**Re: SSD-66826207 - Mixed-use Development - 391-423 Pacific Highway,
3-15 Falcon Street and
8 Alexander Street, Crows Nest (Five Ways)**

Please find below North Sydney Council's submission to the abovementioned State Significant Development Application (SSDA). For the purposes of clarity and interpretation, pursuant to Section 4.5 of the *Environmental Planning and Assessment Act, 1979* and Section 2.7 of State Environmental Planning Policy (Planning Systems) 2021, this submission represents an objection by North Sydney Council.

Figure 8 Proposed site access arrangements

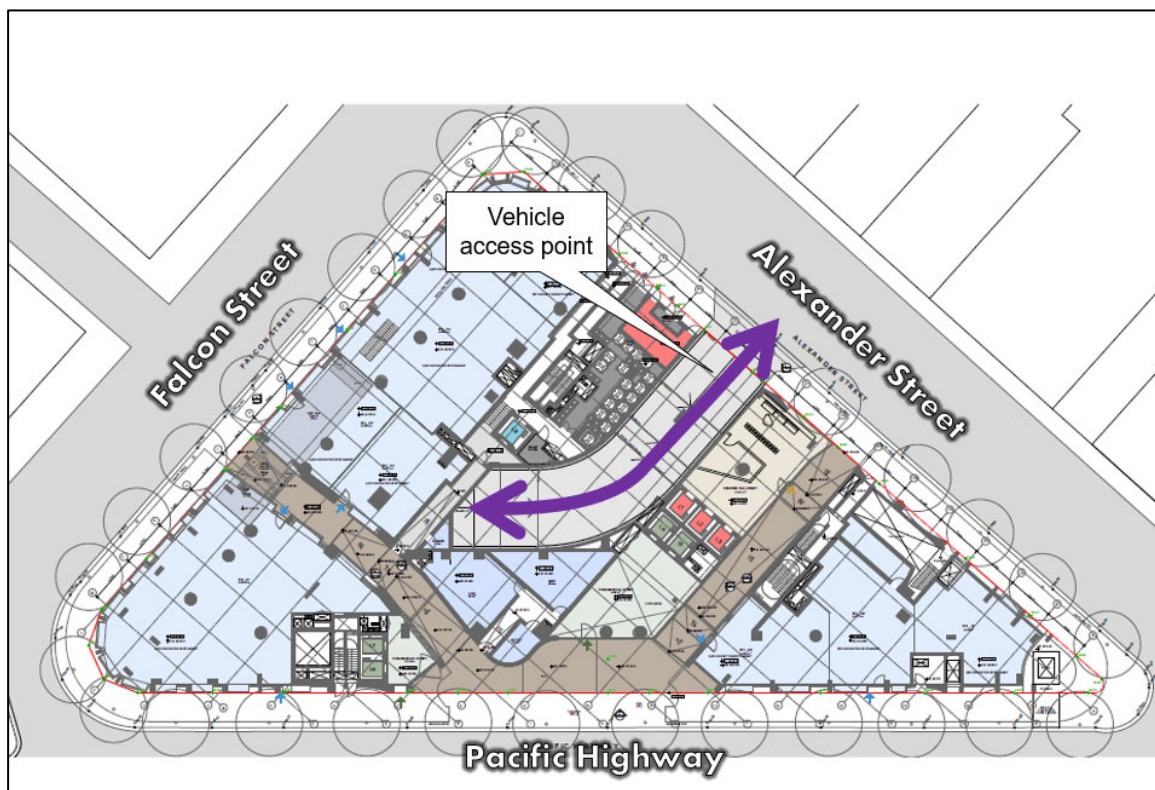
Parking to be reduced - Based on the above the amount of parking for the non-residential spaces should be reduced by 114 spaces with the residential spaces also being reduced. Reducing the total amount of parking will also assist in reducing the excavation required given seven (7) basement levels could be reduced as they would not be required further reducing the cumulative impacts both during and post construction.

The over provision of parking will generate a significant amount of additional traffic movements and the impact upon traffic within this location at the subject site will be significant on what is already a constrained local road network. The amount of non-residential and residential spaces should be reduced to comply with Council's DCP.

Figure 8-7 Residential areas adjacent to the site

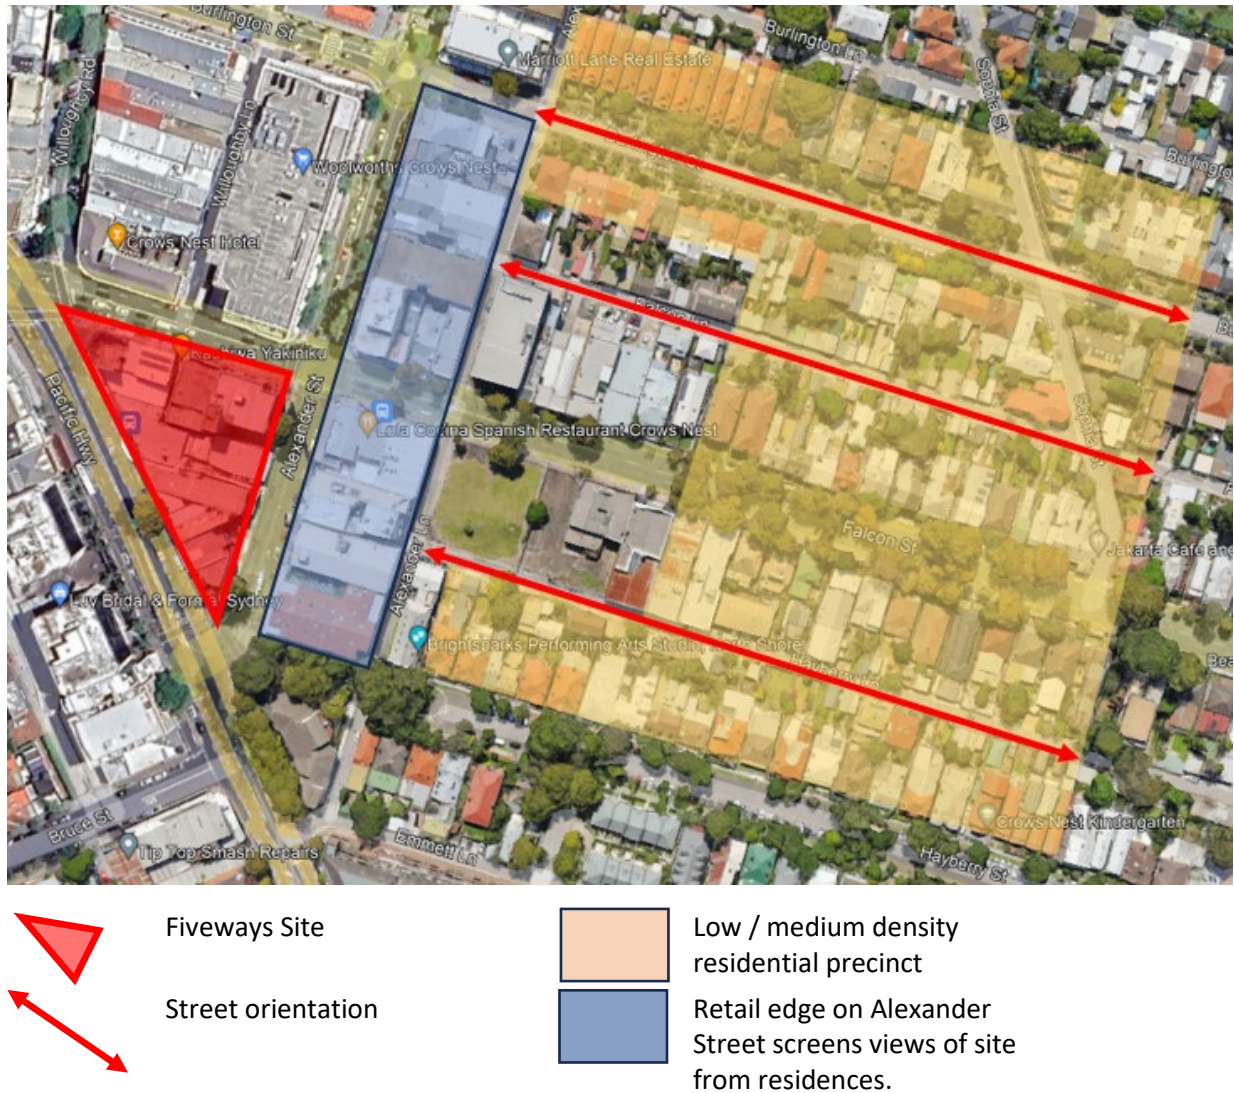
The extent of increase in bulk and scale proposed is further exacerbated by the attributes of the site being at a key junction of major roads and its location along a ridge top where it is effectively viewed in-the-round in a prominent location. The visual impact assessment accompanying the SSDA appears to misrepresent the likely actual extent of apparent building mass that will be visible from the public and private domain. In this regard it is requested that this be carefully reviewed for accuracy and remove any photoshopped trees/structures from the foreground of view impact images.
